Ribble Valley Borough Council
Council Offices
Church Walk,
Clitheroe
Lancashire
BB7 2RA

Phone: 0300 123 6780
Email: Kathryn.Walsh@lancashire.gov.uk
Your ref: 3/2026/0621
Our ref: 3/2026/0621/HDC/KW
Date: 09 September 2026

Location: Kemple Down Birdy Brow Chaigley BB7 3LR
Proposal: Proposed extension and remodelling of existing dwelling including the demolition of the existing self-contained flat and construction of a replacement outbuilding containing garage and garden store.
Grid Ref: 369446 440780

No objection subject to conditions

G Ground Floor Plan
Scale: 1:100

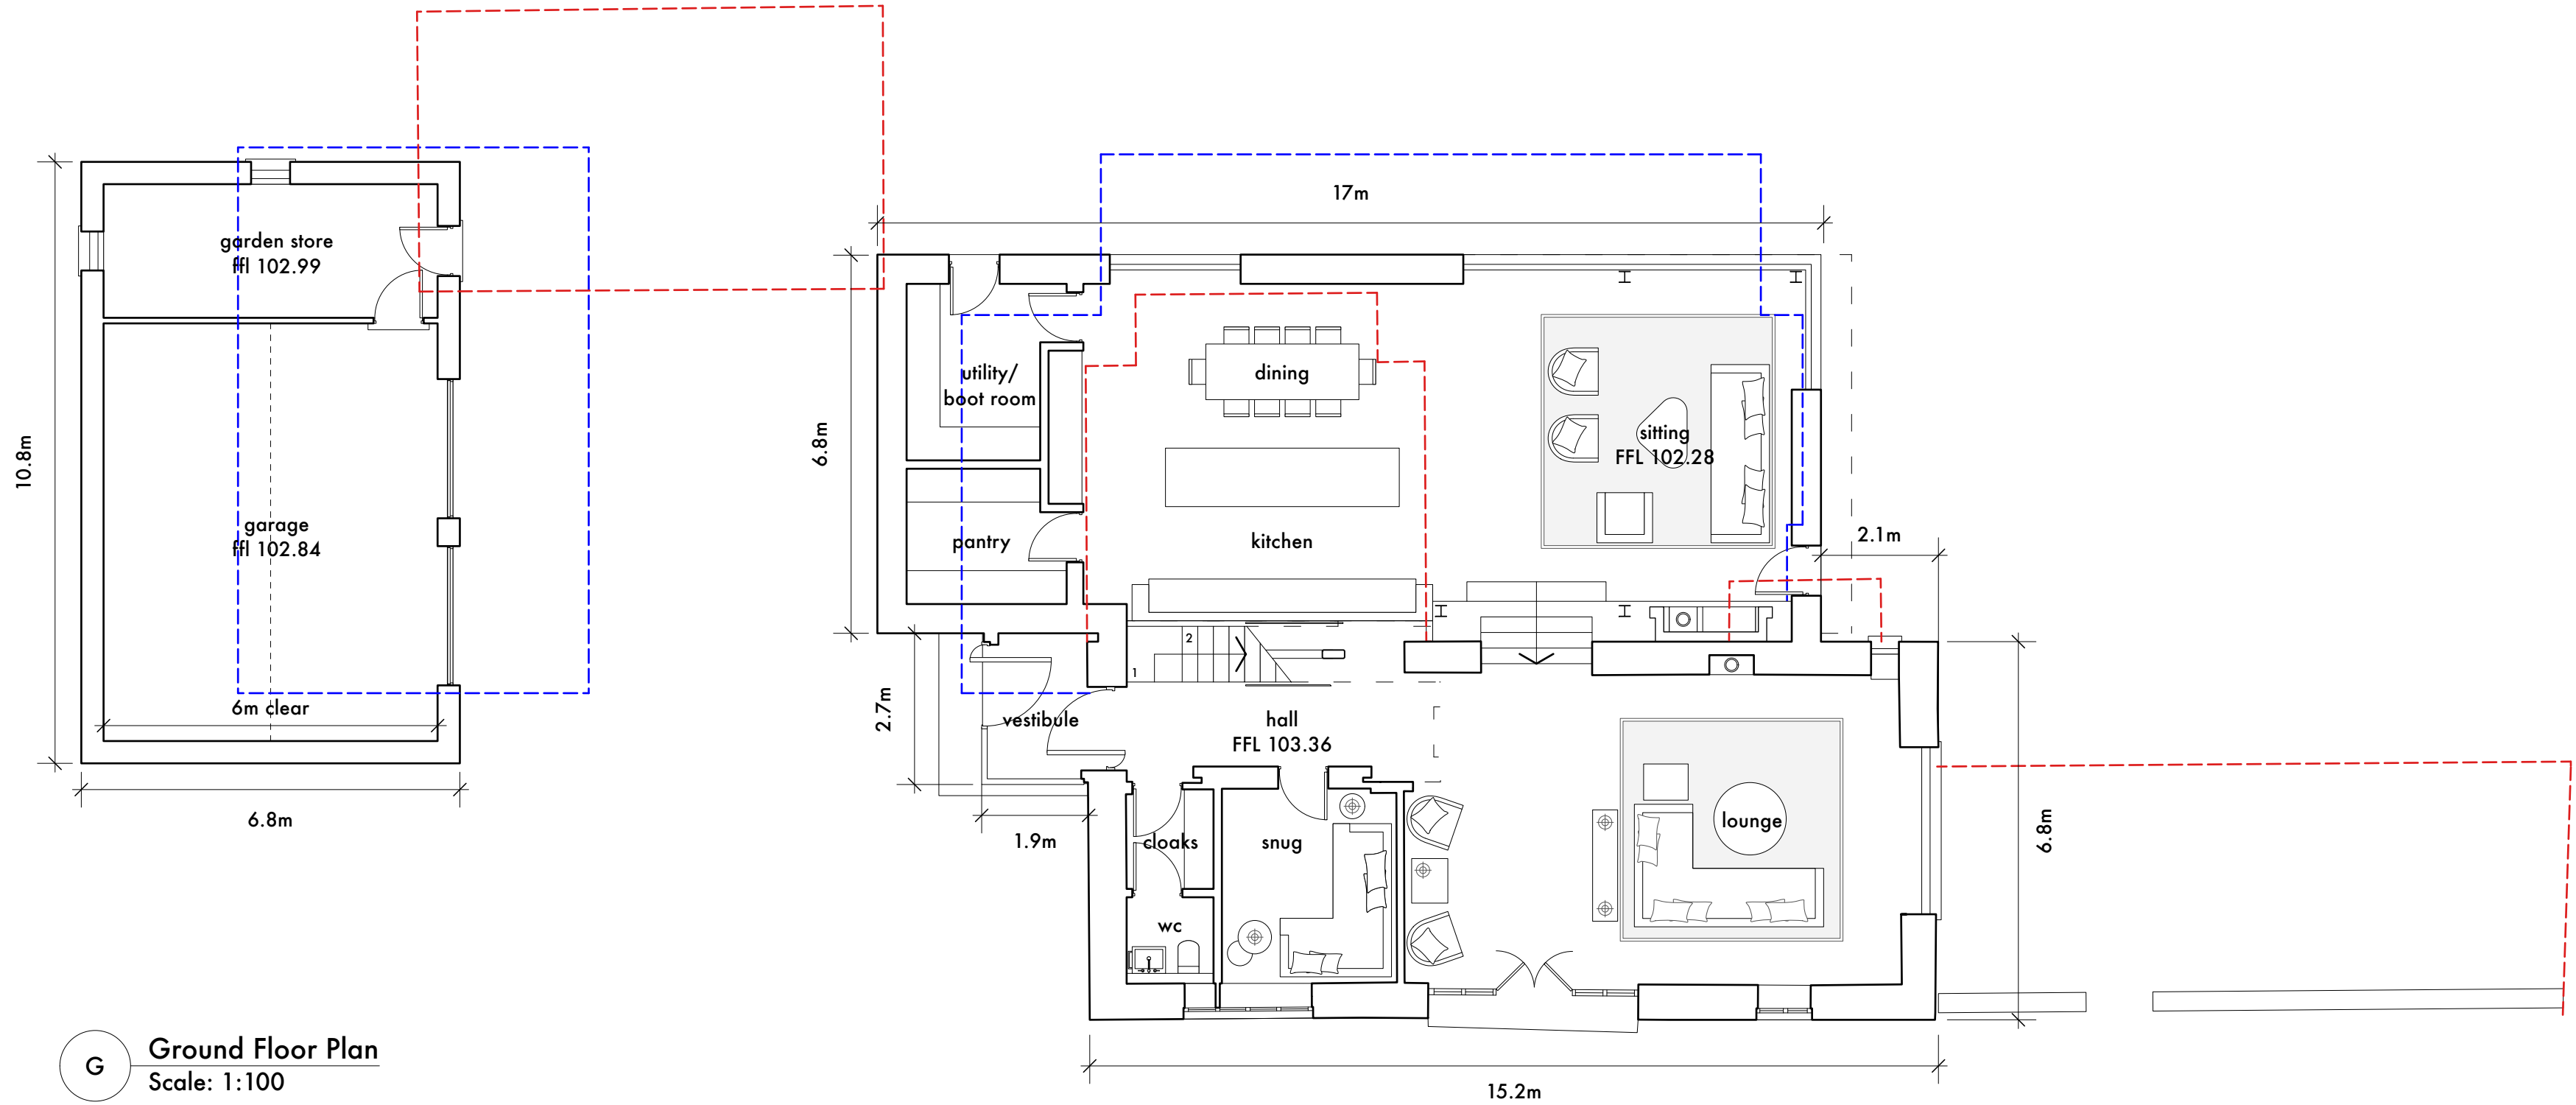
The recommended minimum internal dimensions for a double garage size is 6m in length and 6m wide. The LHA has reviewed the proposed floor plans, drawing PL.11 Revision A and note that the double garage meets the recommended minimum internal dimension of at least 6m x 6m, there is also adequate parking and turning provisions within the proposed driveway; as such, the proposal complies with the LHAs parking standards as defined in the Joint Lancashire Structure Plan. It is also noted that the proposed garage or garden store can also support covered, secure cycle storage.
